Entech Responses to Colorado Geological Survey comments dated 10.26.2021

Shallow groundwater and basement feasibility.

JOB NO. 25188.02
 DECEMBER 20, 2021
 SHEET 2 OF 3

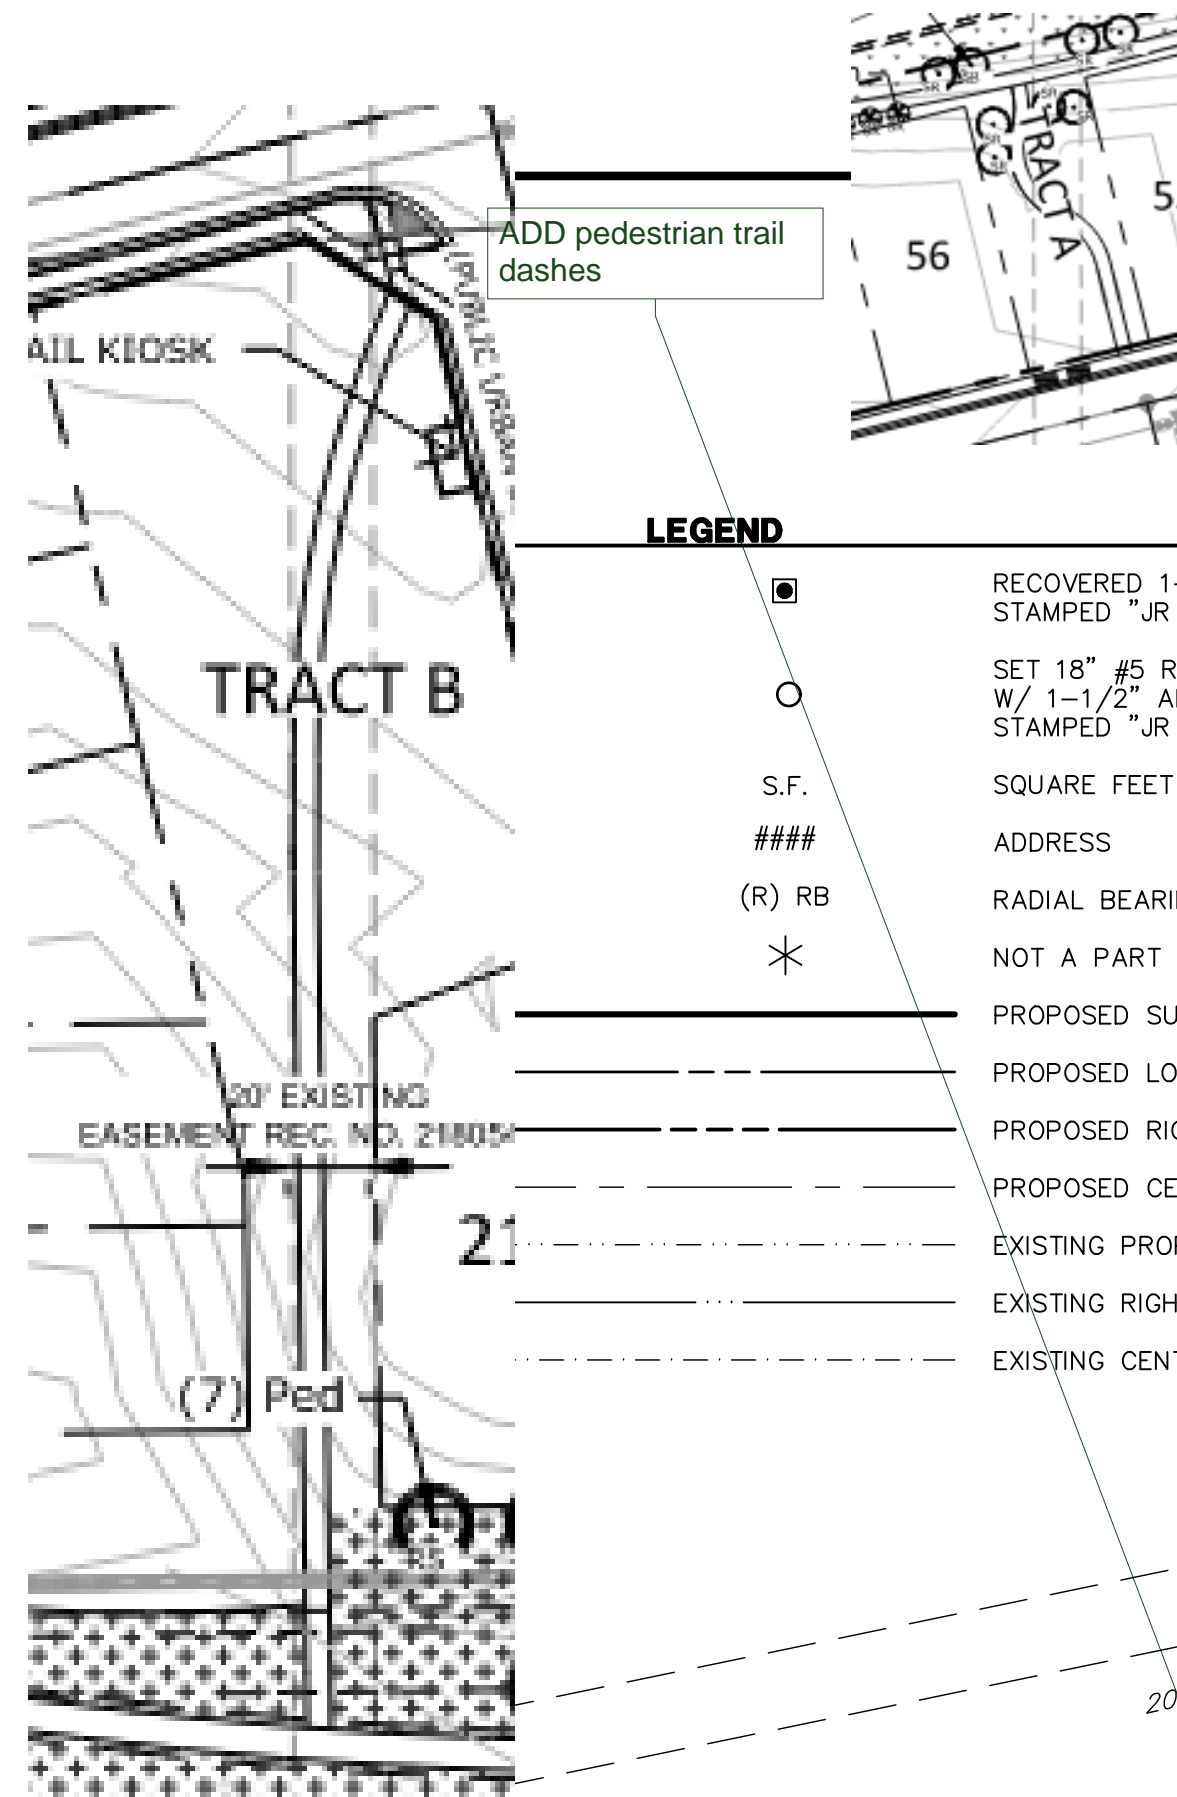
Shallow groundwater and basement feasibility. As indicated in the Letter of Intent (August 2021), "Some areas of Phase 2 were found to be impacted by shallow groundwater, and certain lots were prohibited from having basements as mitigation. None of these lots are within Filing 3..." However, groundwater was encountered in TB-2 (within Filing 3 near Lots 16 and 17) at a depth of 7 feet below grade.

According to the grading plan, the area around TB-2 will not be filled during grading operations. The feasibility of basements for Filing 3 due to shallow groundwater, seasonally shallow groundwater, and perched groundwater on shallow bedrock is not discussed in Entech's report.

RESPONSE: Groundwater was encountered at depths of 7 to 12 feet below the existing surface grade. Test Boring No. 2 located along the southern side of the site had the highest groundwater level, and was drilled during a period of increased precipitation in 2019. A minimum separation of 3 feet between foundations and highest seasonal groundwater level is recommended. The potential for perched groundwater conditions on the shallow bedrock exist on this site. It is our understanding an underdrain system will be installed along the sanitary sewer on the site. Individual building drains can be tied into the underdrain. Recent test borings (1A and 2A) showed water at 12 and greater than 20 feet. Test boring logs are included in the report (Appendix B).
